Aldwick Bay Estate

9th April 2021

Planning Applications No. AW/75/21/HH & AW/85/21/HH

DRAWING: Site Plan SCALE: 1 : 200

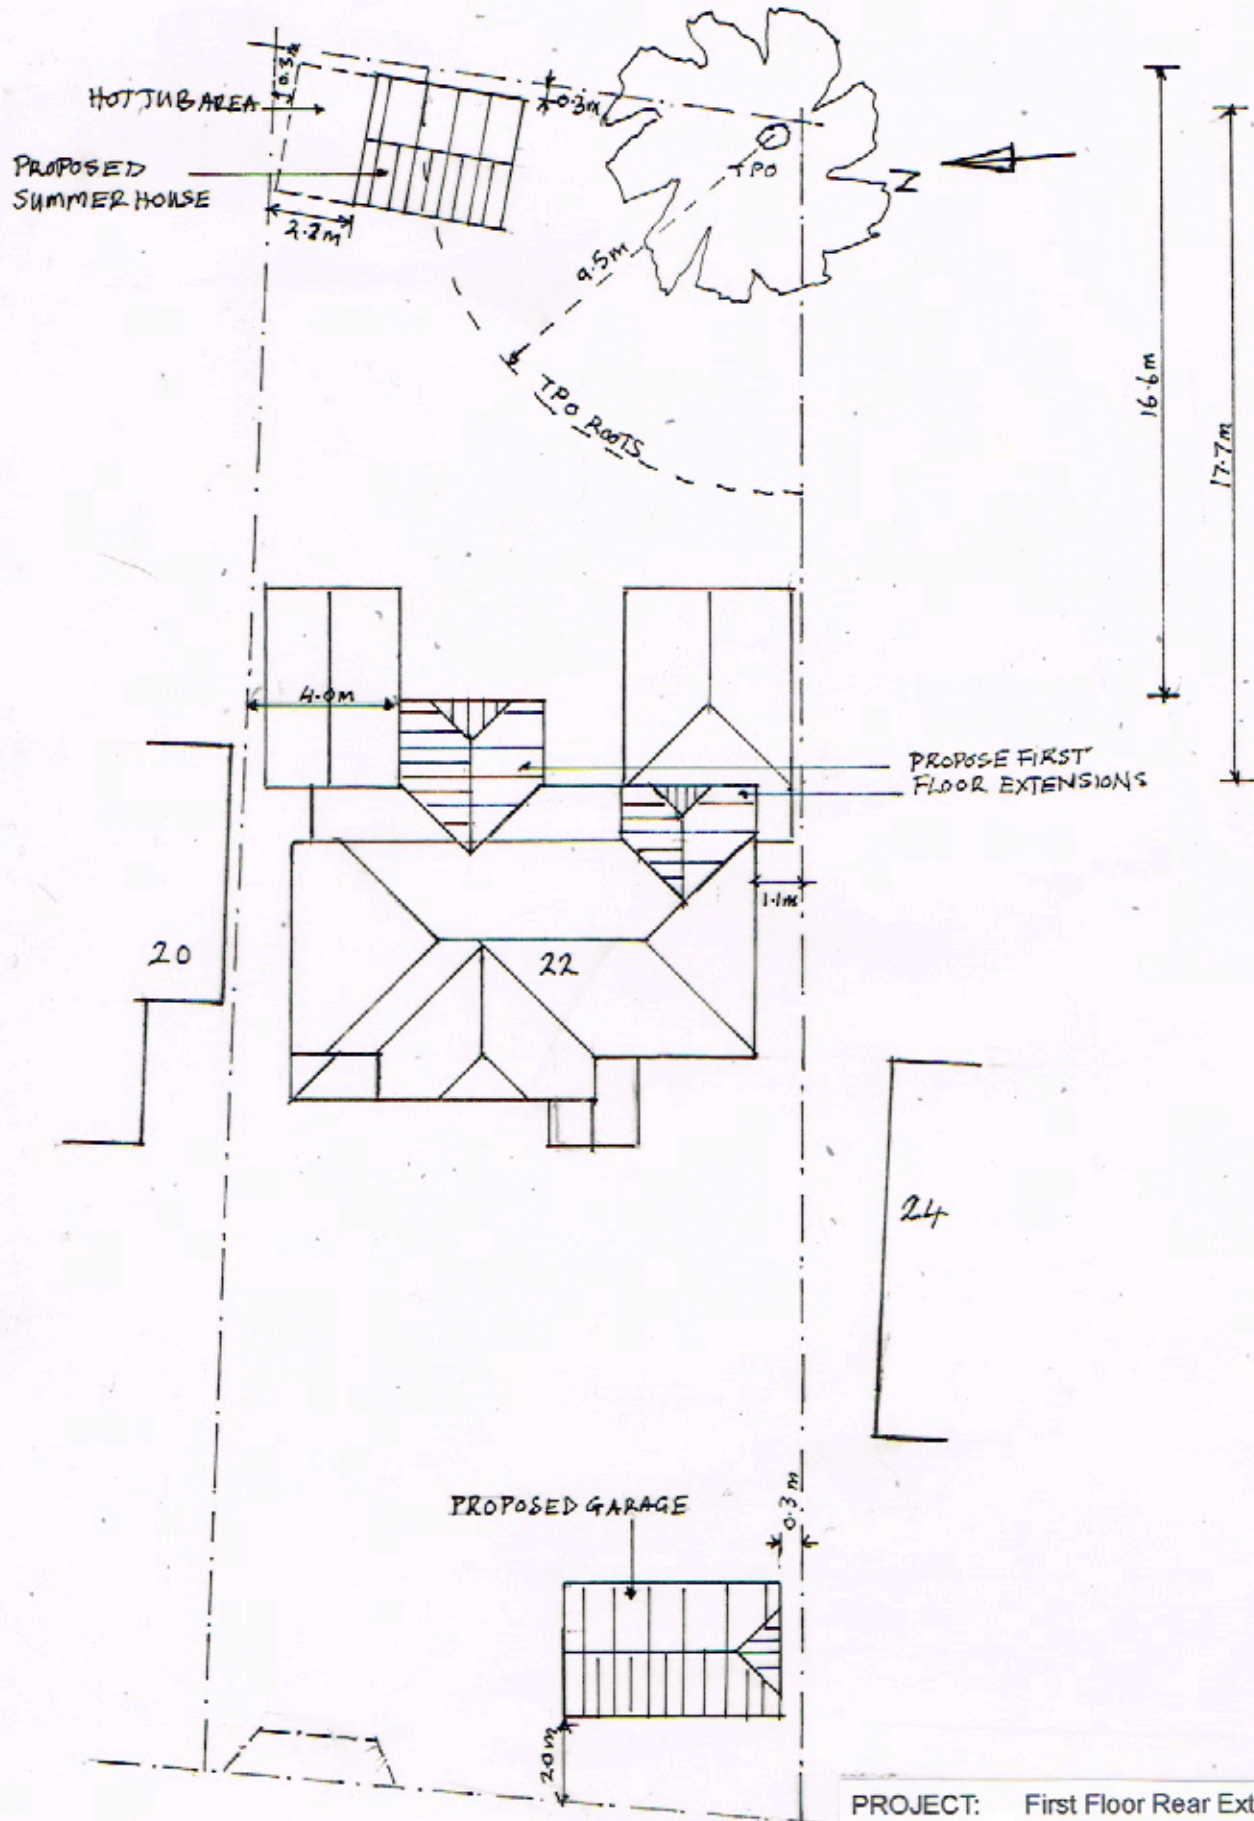
Regarding the application for the first-floor extensions, front detached garage, and rear garden summer house we feel that we could not support the detached front garage in its proposed position as it is forward of the general building line on the east side of A'Beckets Avenue. We feel this would create an unwelcome precedent and would be detrimental to the general street scene. We could only support such a garage if it were no further forward than the house at No24 A'Beckets Avenue.
